THE PURPOSE OF THIS ADDENDUM WAS TO COMBINE PARCEL 70 WITH 68 AND ELIMINATE PARCEL 70. COMBINE PARCEL 72 WITH 71 AND ELIMINATE PARCEL 72. MODIFY THE PERMANENT UTILITY EASEMENT ON PARCEL 81 AND PARCEL 82.

PROJECT REFERENCE NO. I-5987A	SHEET NO. RW17A
<b>Location and Surveys</b>	
NCDOT LOCATION AND SURVEYS DIVISION 6 FIELD OFFICE	
PROJECT SURVEYOR

PROJECT REFERENCE NO.	SHEET NO.
I-5987A	RW17A
Location and Surveys	
NCDOT LOCATION AND SURVEYS DIVISION 6 FIELD OFFICE	
PROJECT SURVEYOR

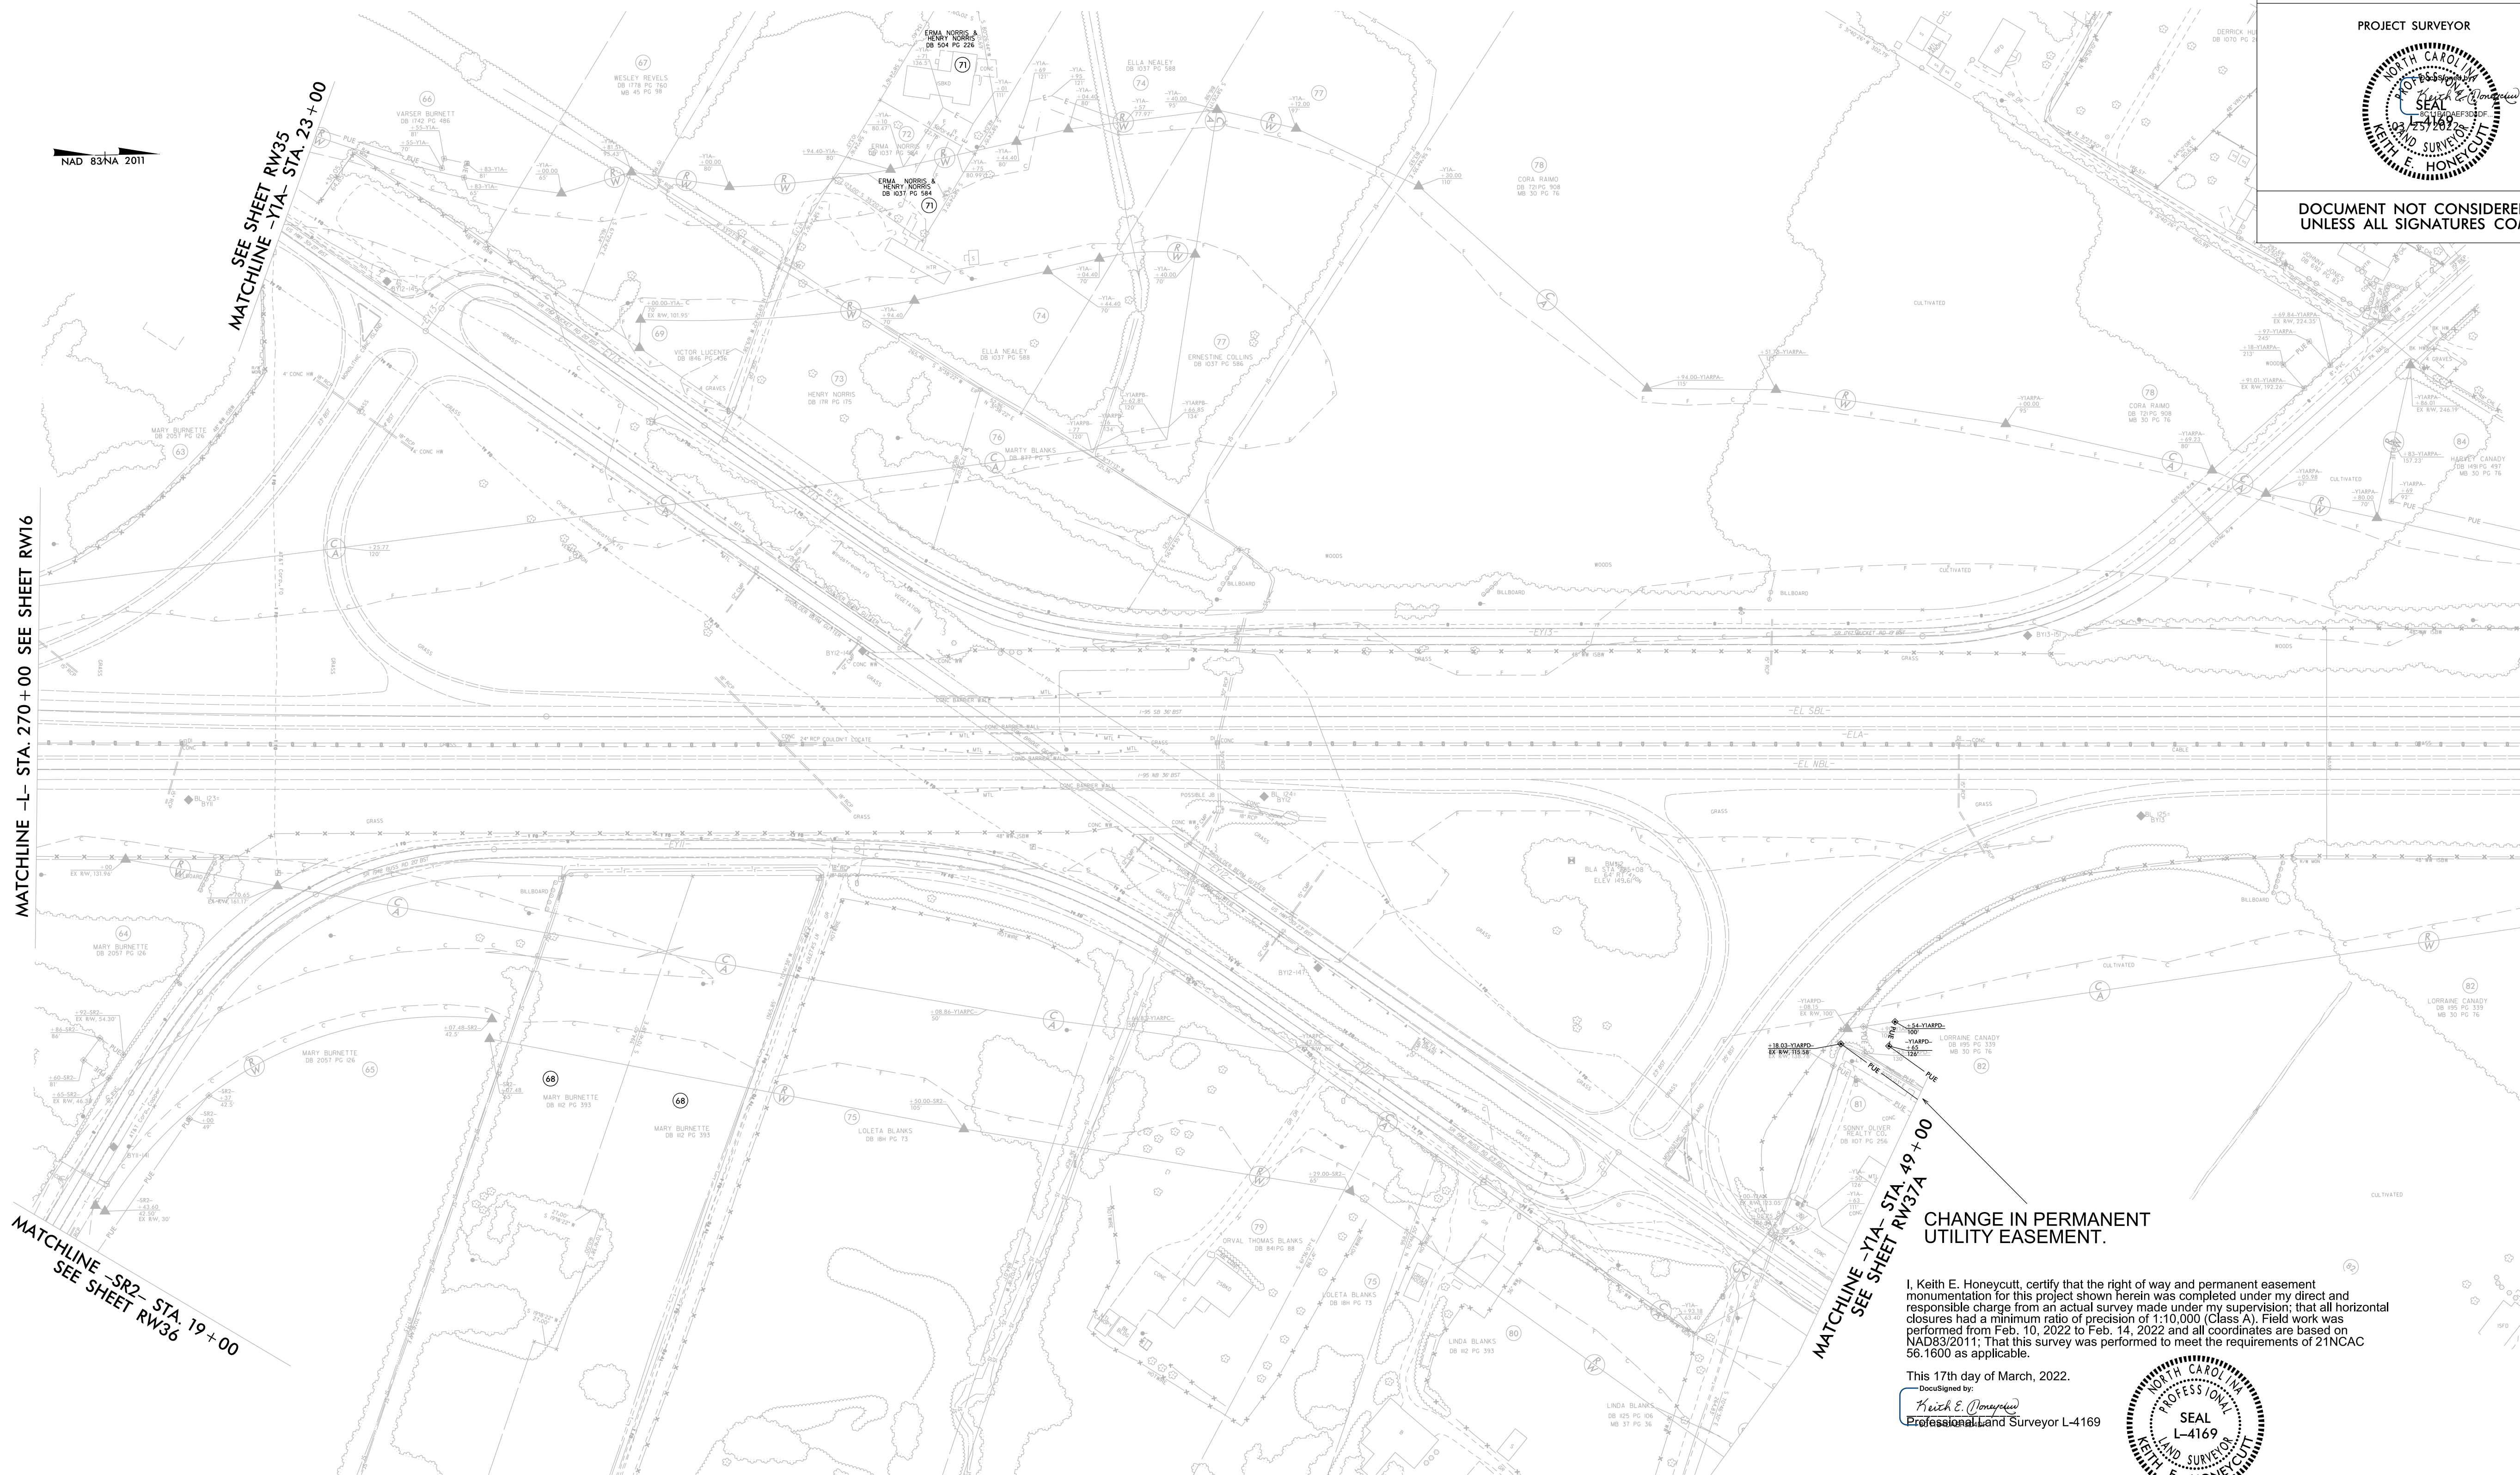
CHANGE IN PERMANENT UTILITY EASEMENT.
